**Re: 614 1st Street, Parking Lot Improvements
Grading and Drainage Plan
Engineer's Stamp Date 8/27/2013 (J14/D006)**

Based upon the information provided in your submittal received 8/27/2013, the following comments have to be addressed prior to an approval for Grading, Paving, and SO-19 Permit:

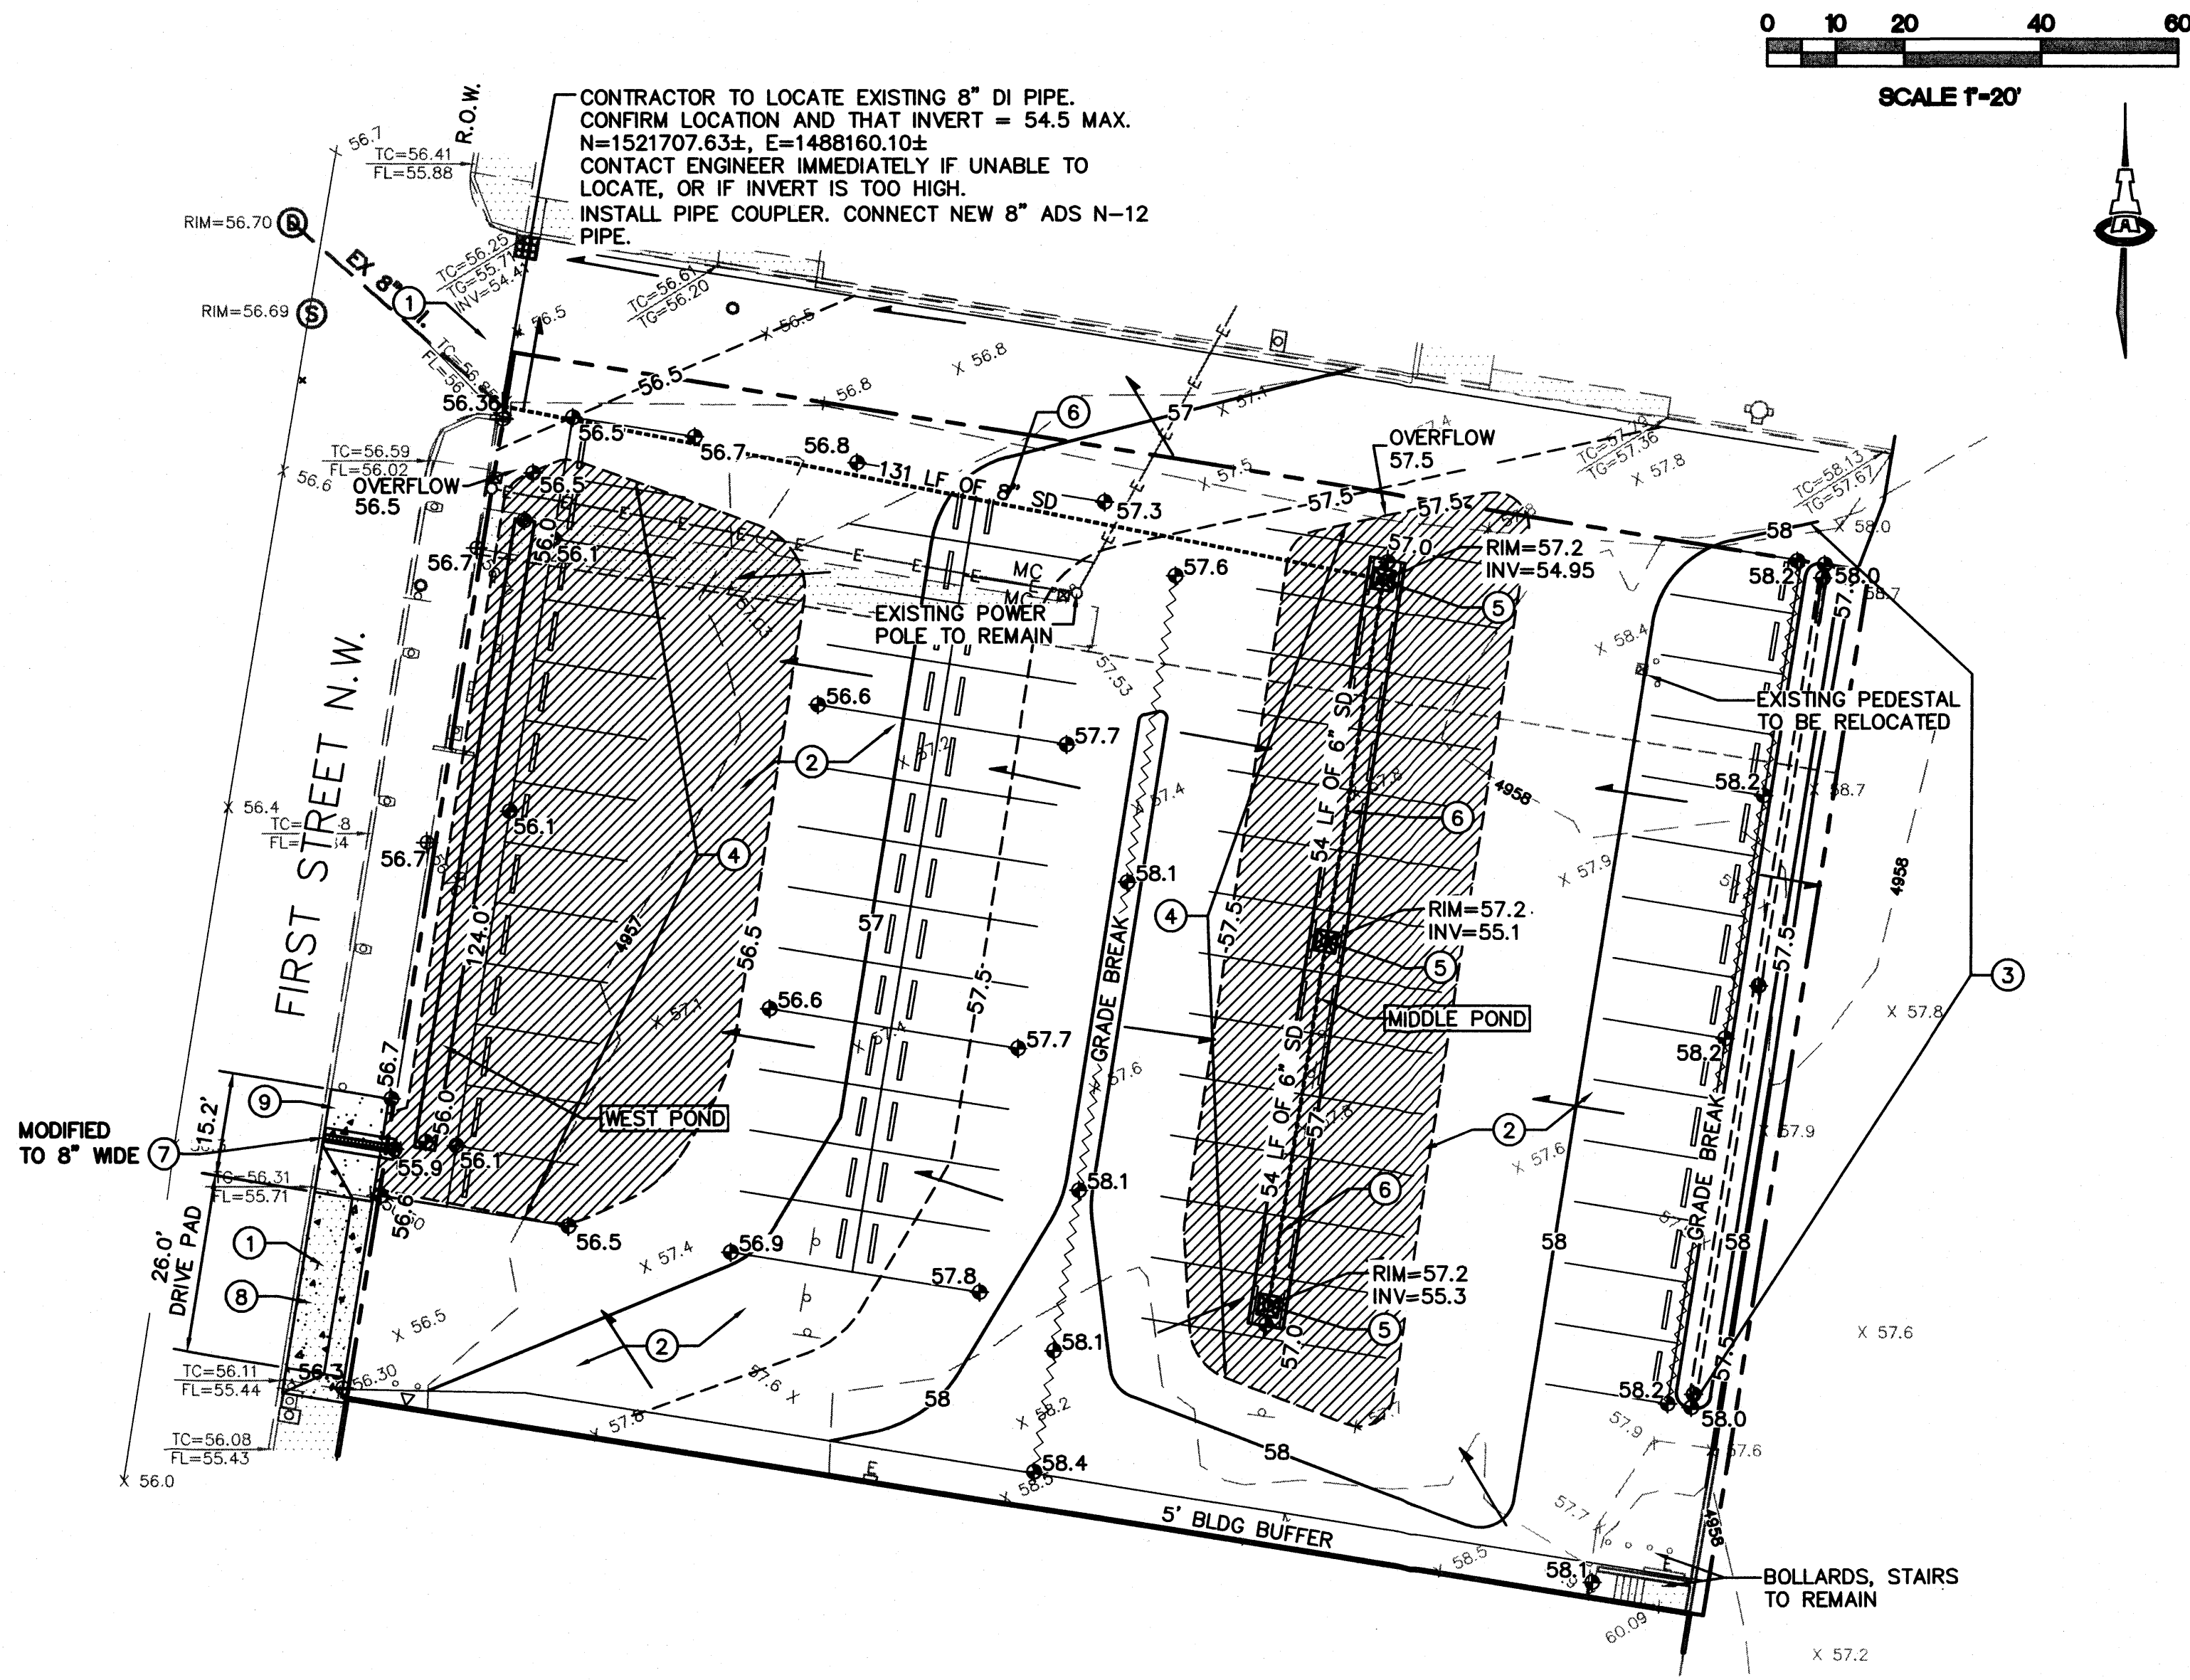
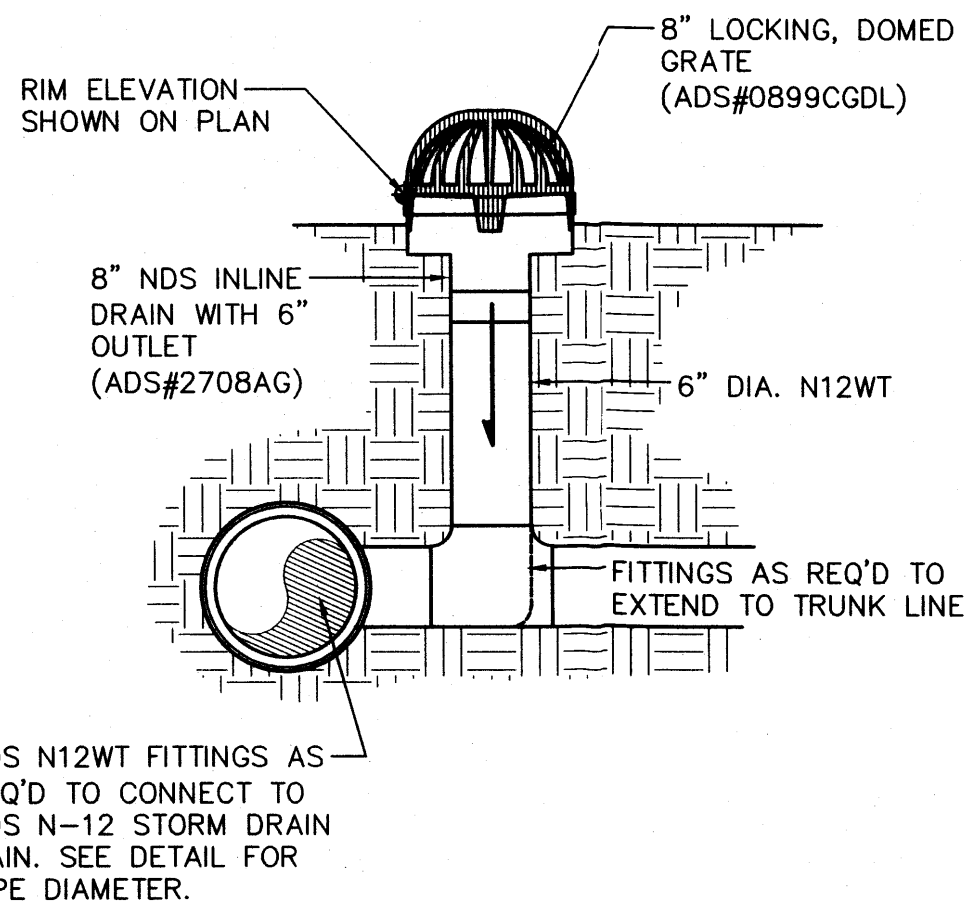
- The treatment used for the paved area should be treatment D instead of C.
- No runoff enters the easterly pond.
- The middle pond does not retain any runoff.
- Is there an access and drainage easement on the northerly property? Please provide documentations.
- The broken sidewalks fronting this project should be removed and replaced.
- Are the existing driveways built to City of Albuquerque standards? If not, the driveways should be reconstructed to City of Albuquerque runoff from the
- Is the existing inlet "Type D" inlet? The grate must be per City of Albuquerque Standard Drawing Number 2220.
